jb planning associates

Our Ref: PA/1040/sf
Your Ref: S6/2011/1994/MA

22 December 2011

Salisbury Square, Old Hatfield

AREA OF HIGHWAY TO BE STOPPED

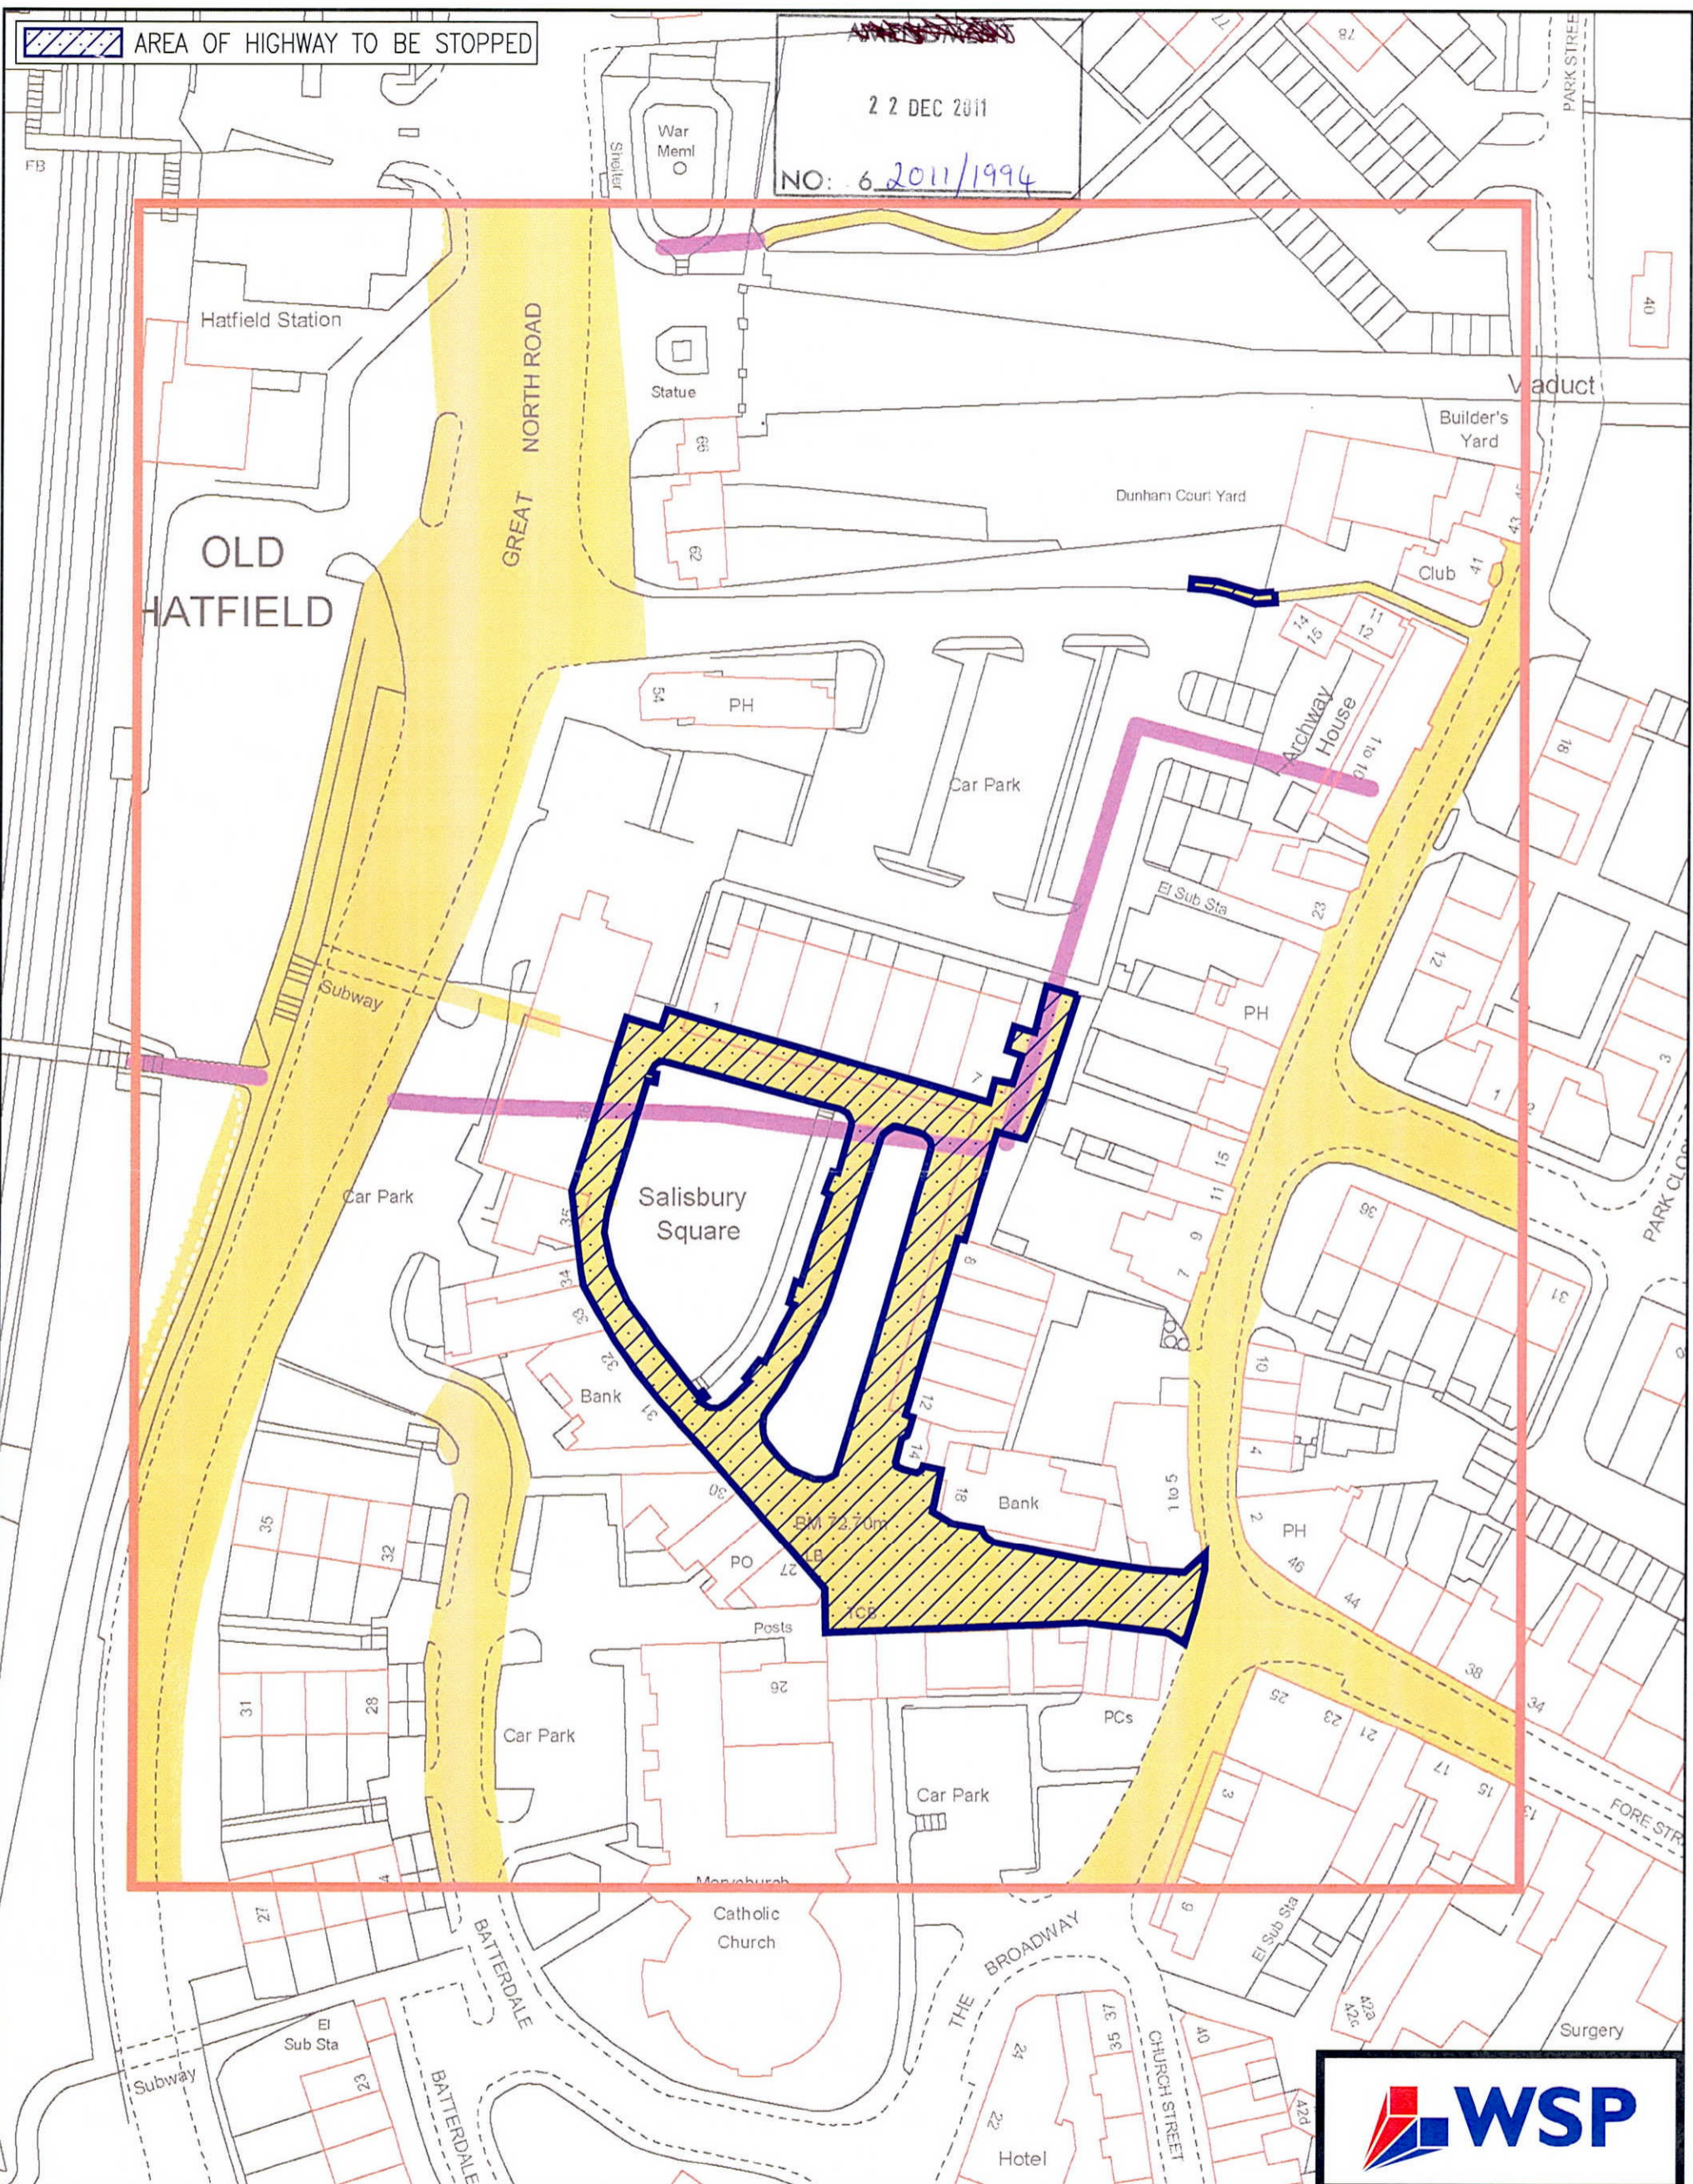
- 1) Please see attached sketch **1458-SK-001** which indicates the area of highway to be stopped-up. This includes all existing highway land that lies within Salisbury Square (and which is currently pedestrianised) up to and including the junction with Park Street. We understand that Mr Dale and Lindsey Lucas discussed the principle of this previously with WSP (back in March) and that an application under s247 of the Town and Country Planning Act 1990 would be necessary in due course once the current planning application has been determined. We will be grateful if you could confirm HCC's position and (in consultation with HCC) advise on the requirements.

FIGURE NO:
1458/ATR/005

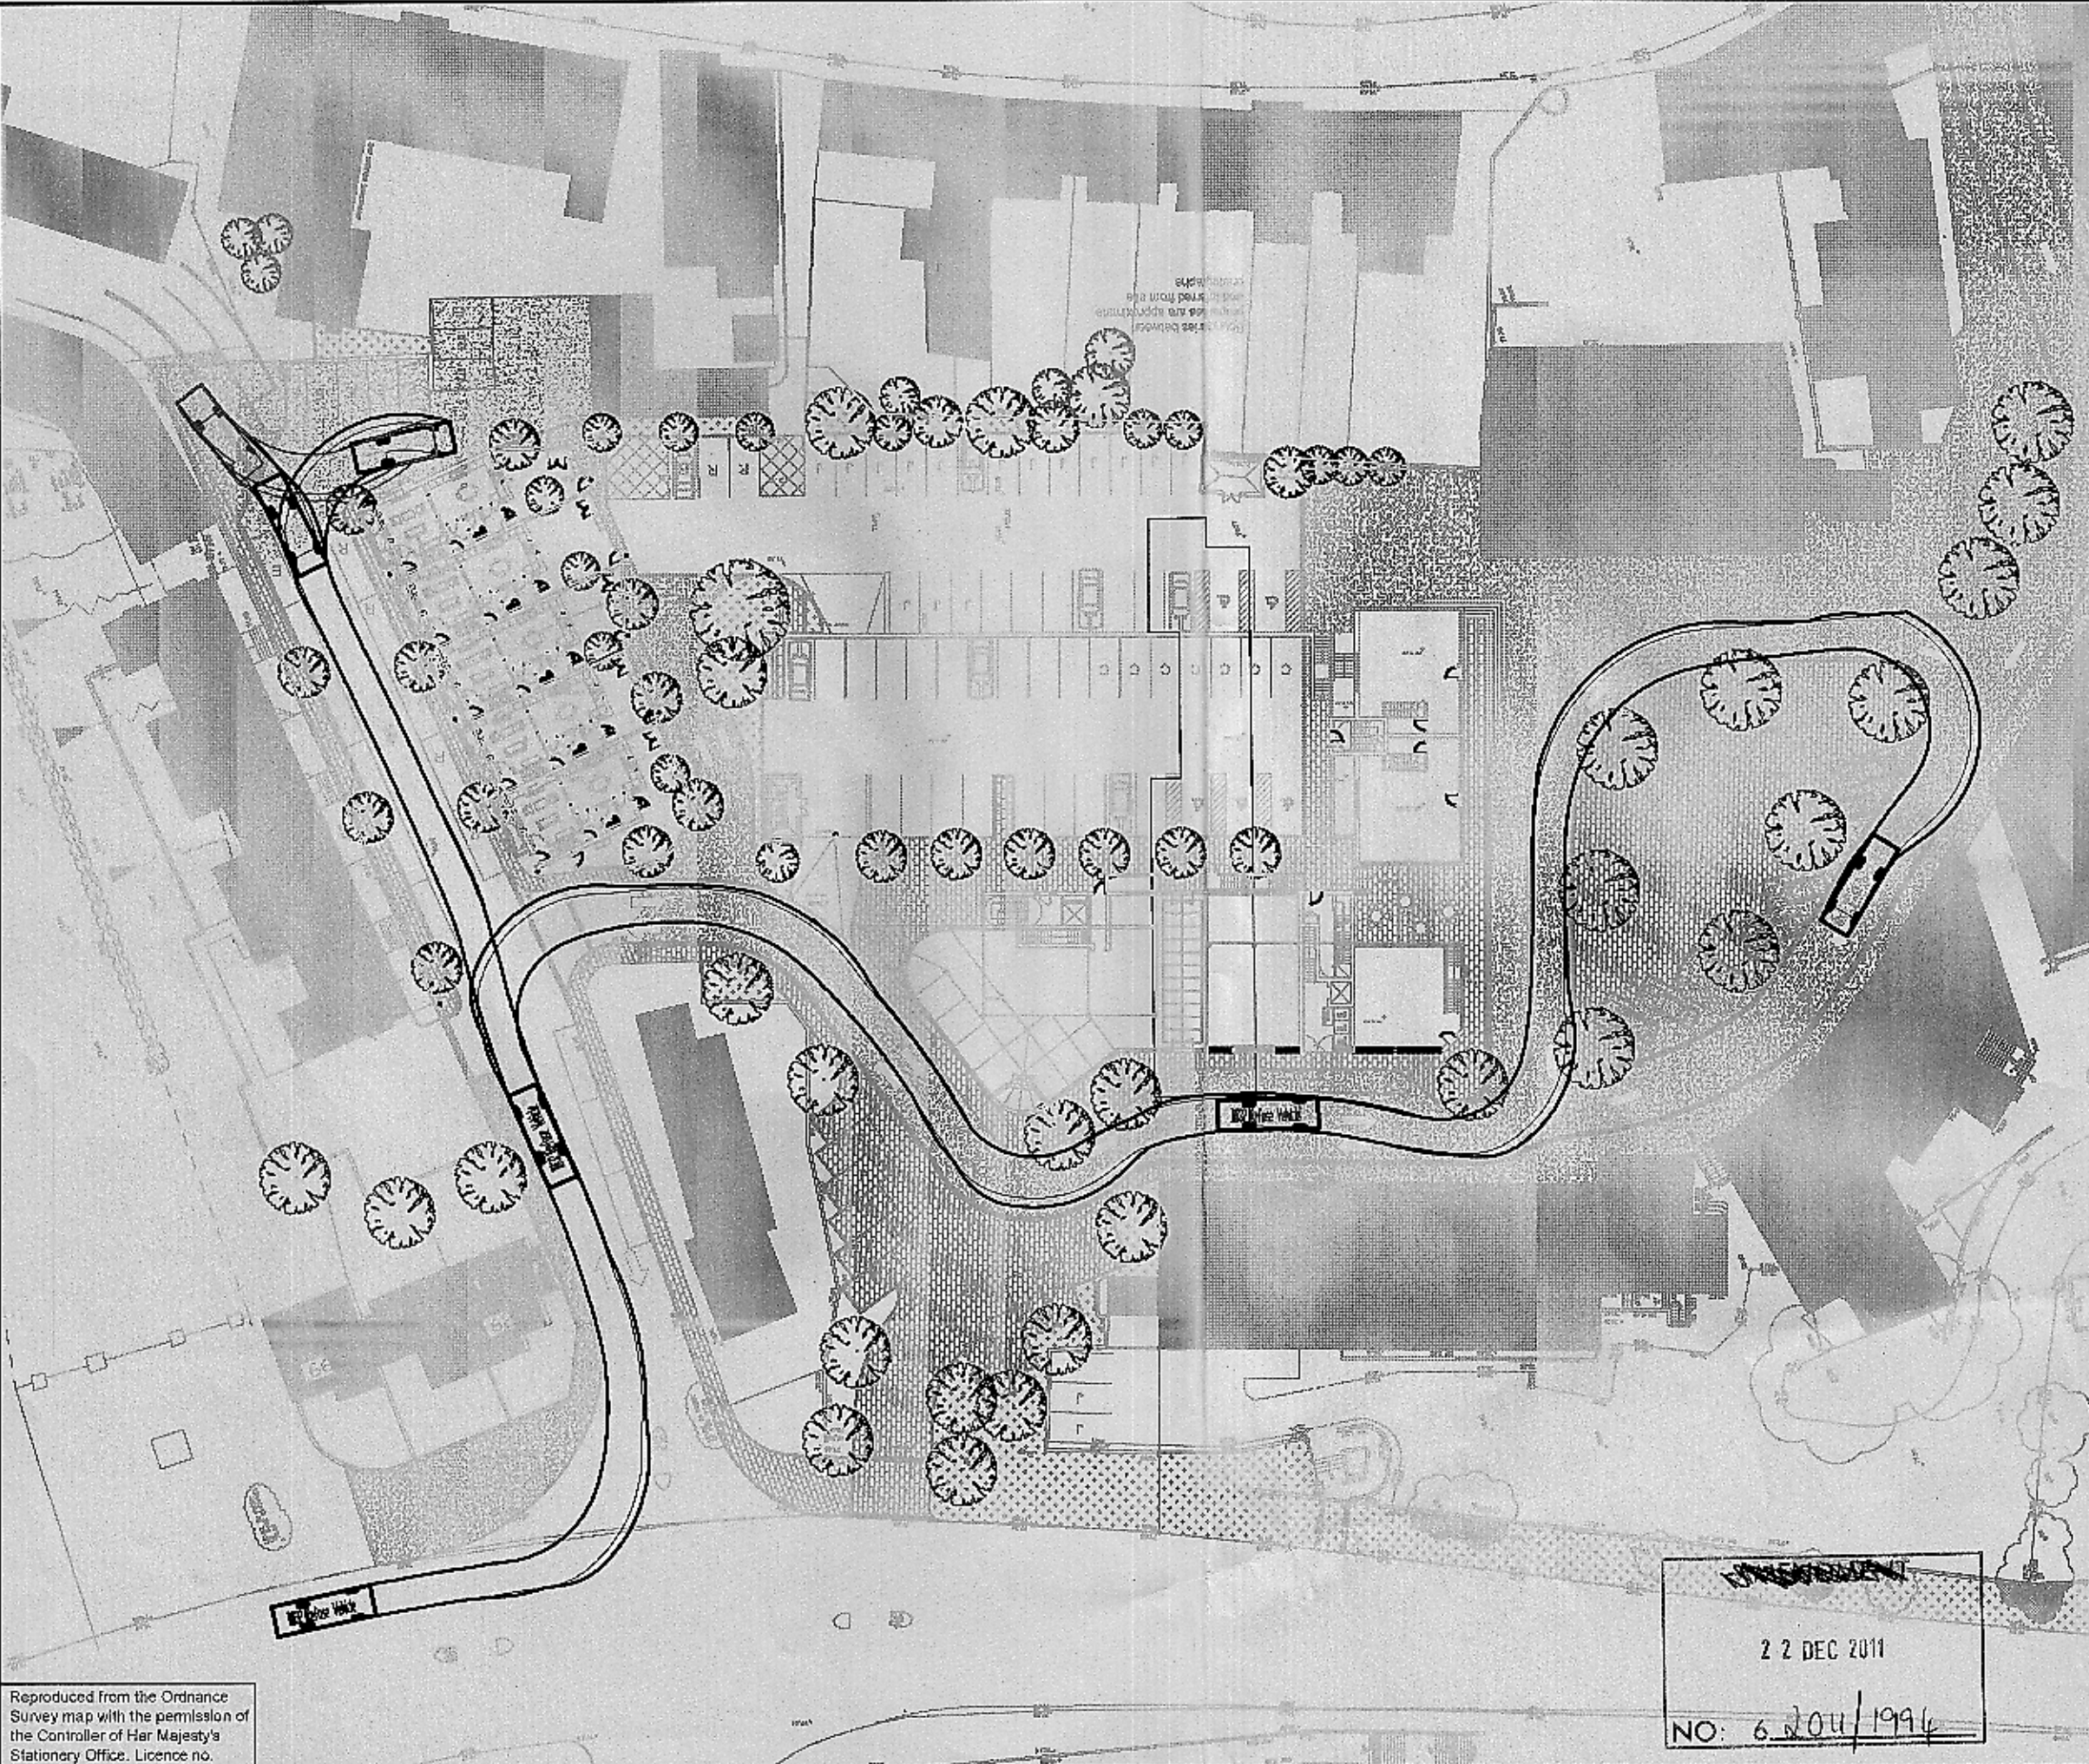
- 5) Please see vehicle tracking plots Drawings **1458/ATR/005** and **1458/ATR/006** attached as requested by Mr Dale. Track plots over-run in some areas but noting comments in 4 above, in the applicants view (and WSP's) this is considered acceptable. The applicants also point out that the Borough Council use the "smaller" dustcart type vehicles in Old Hatfield given the historic street layouts etc.
